28 October 2019

SF2017/281322; WST17/00197/08

**SSD-9505: Lot 1 DP 1058009 and others; 2816 Mid-Western Highway (HW6), Kings Plains
Environmental Impact Statement (EIS)
McPhillamys Gold Mine with 8 Mtpa extraction limit**

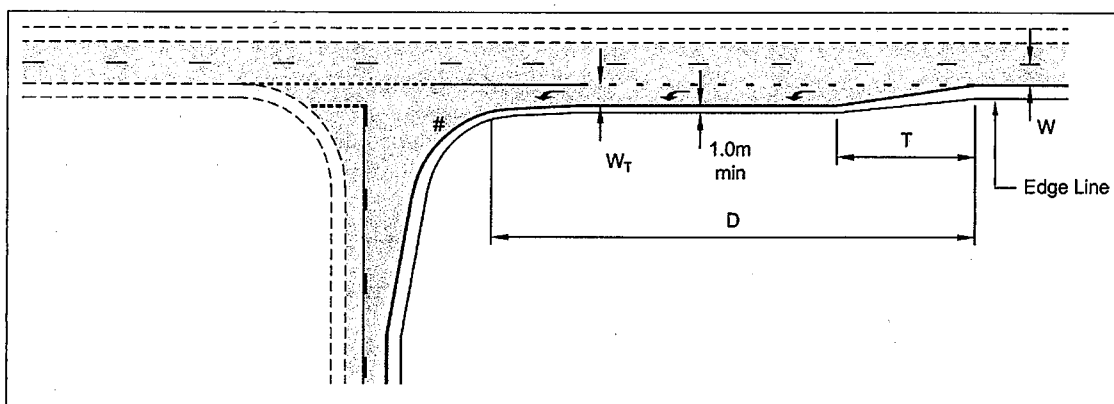
- Prior to commencement of any construction work, an Auxiliary Left turn treatment (AUL) as shown in Figure 8.4 Part 4A of *Austroads Guide to Road Design* (copy enclosed), and relevant Roads and Maritime supplements is to be provided at the proposed intersection with the Mid Western Highway. The intersection works are to be designed and constructed for a 100km/h posted speed zone and be able to accommodate the largest vehicle accessing the intersection.
